Ref; Planning Application BE/60/15/PL

To be discussed at the Development Control Committee Meeting 23rd September 2015

Dear Councillor

EAST ELEVATION
(1:100)

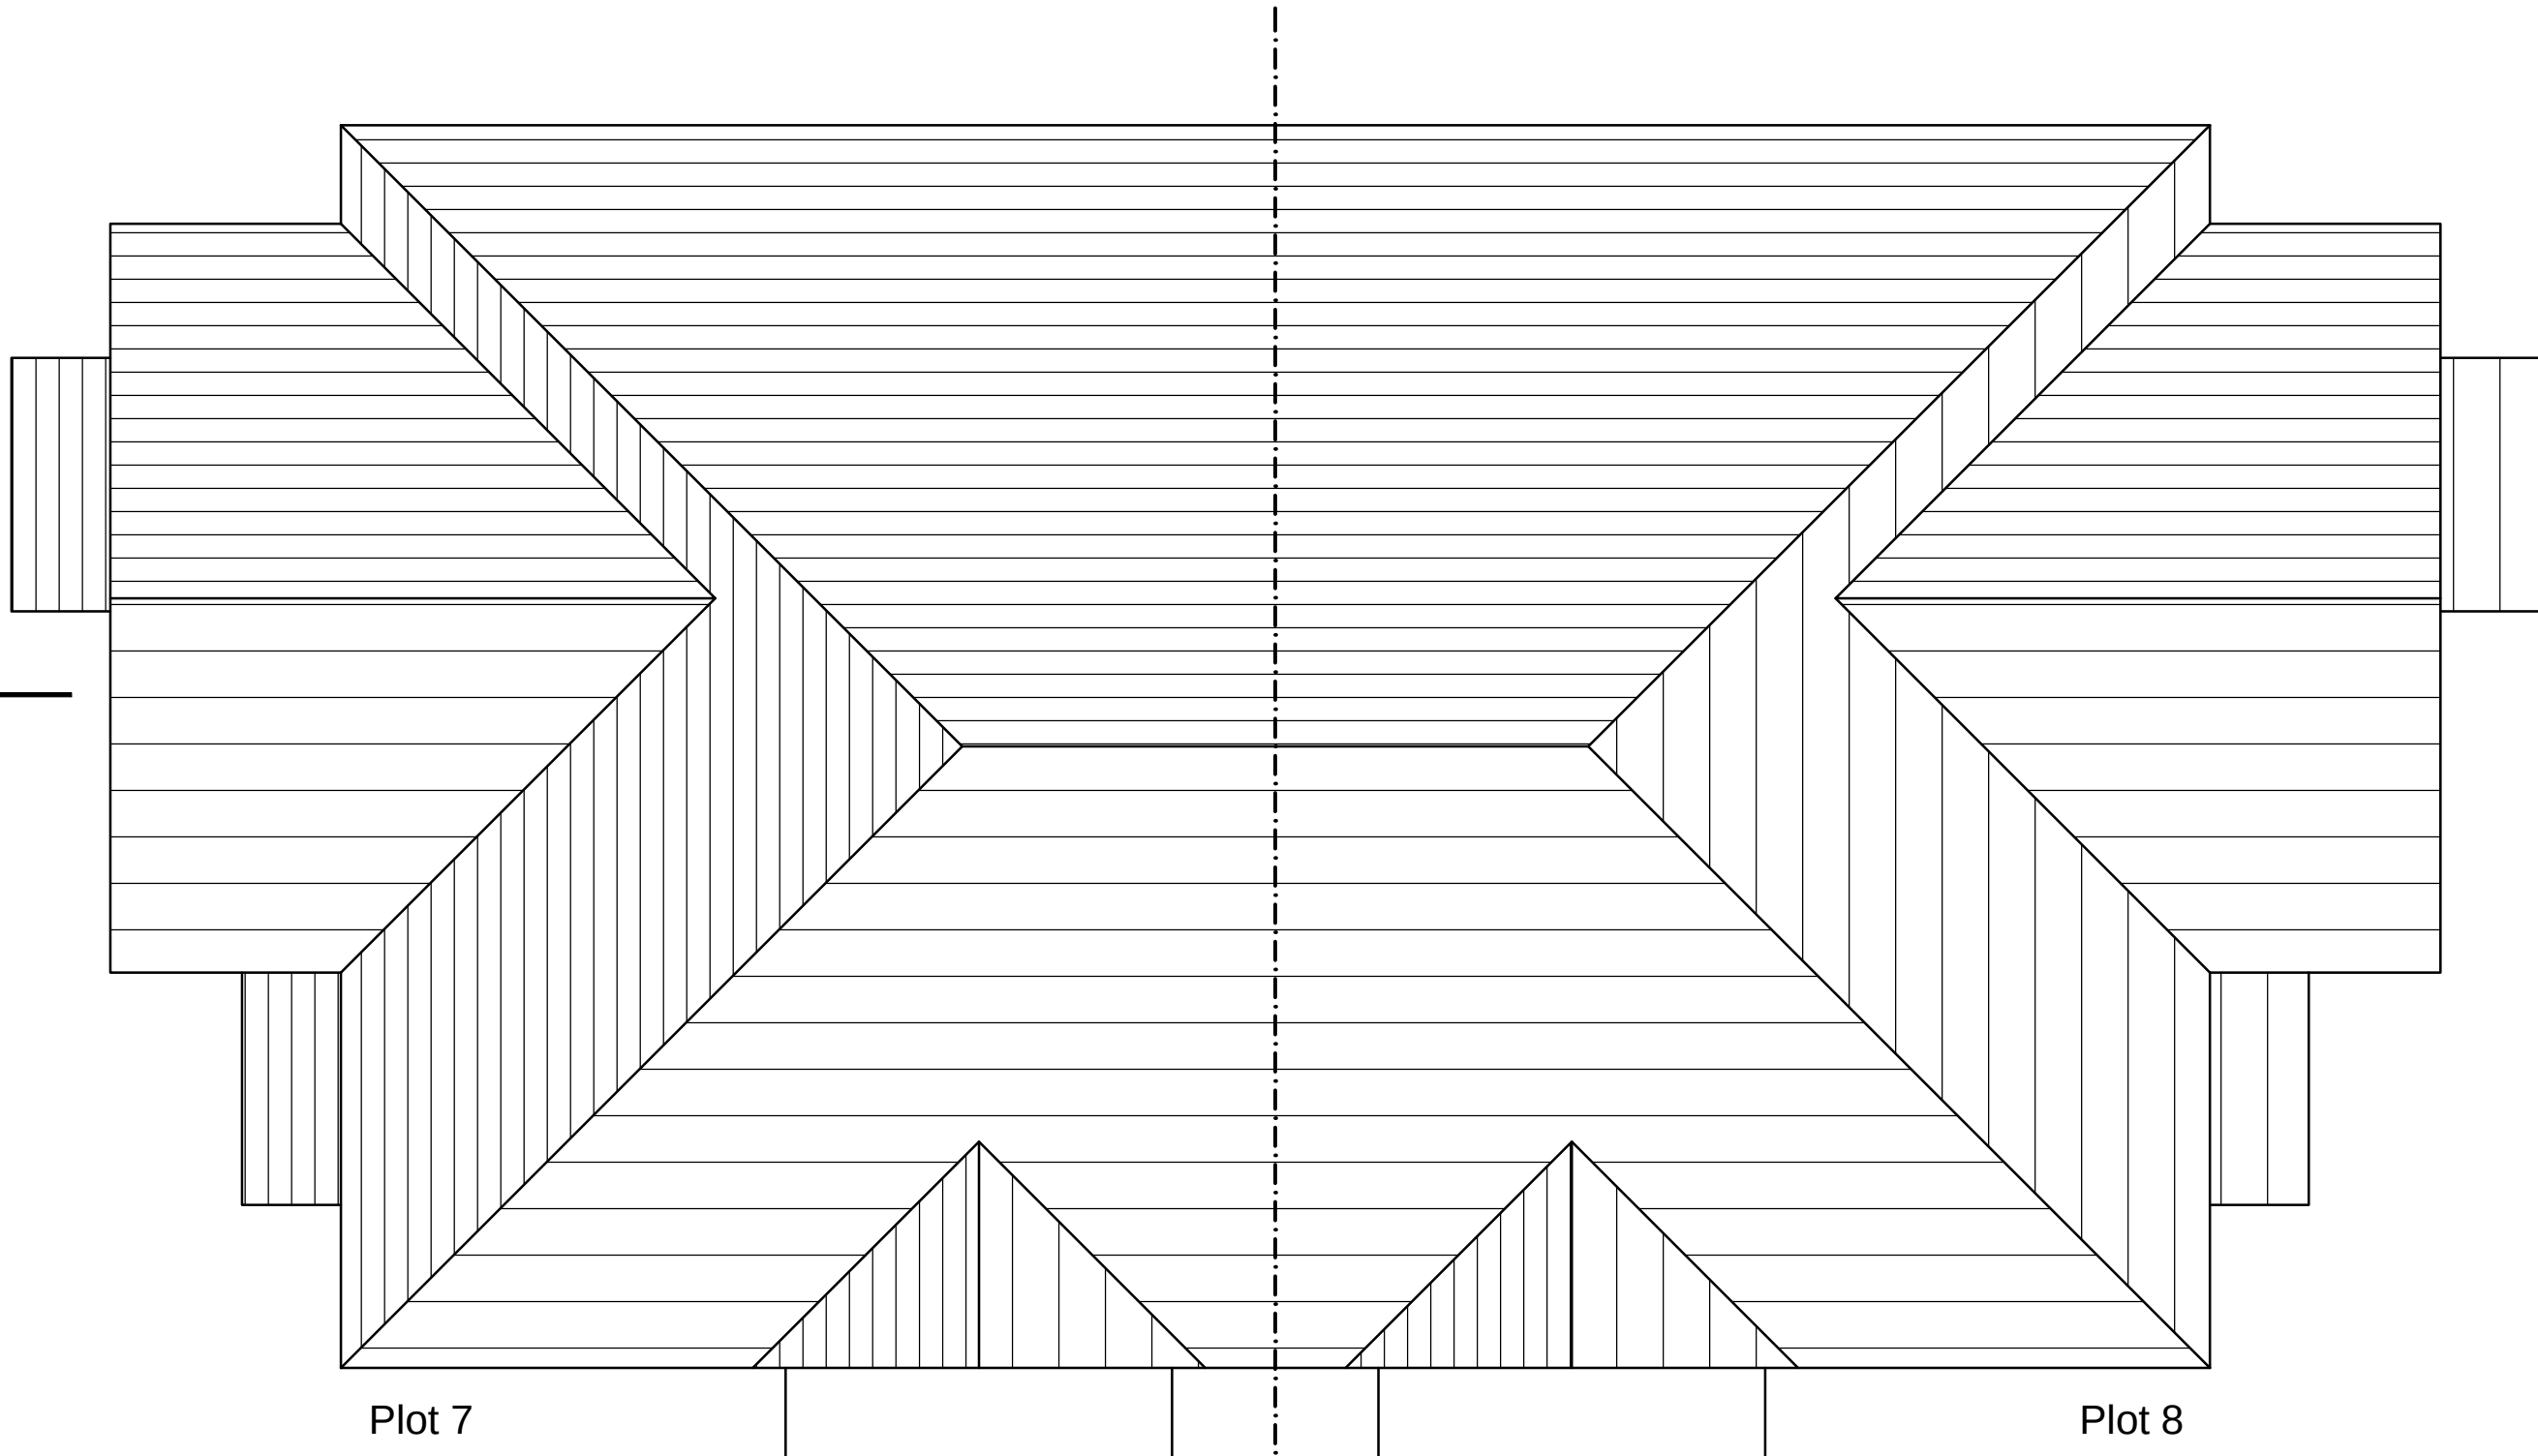
- There is unacceptable noise and disturbance to 15 & 17 by the changed vehicle parking and manoeuvring to plots 7 & 8.
- The first floor windows comprising bedroom 3, landing and bathroom of plot 8 over look existing numbers 15 and 17. These properties are occupied by the vulnerable elderly and young families. The windows are unneighbourly, directly compromise the privacy of these residents and would form an unsatisfactory backland development which would harm the privacy and quiet enjoyment of these neighbouring properties.
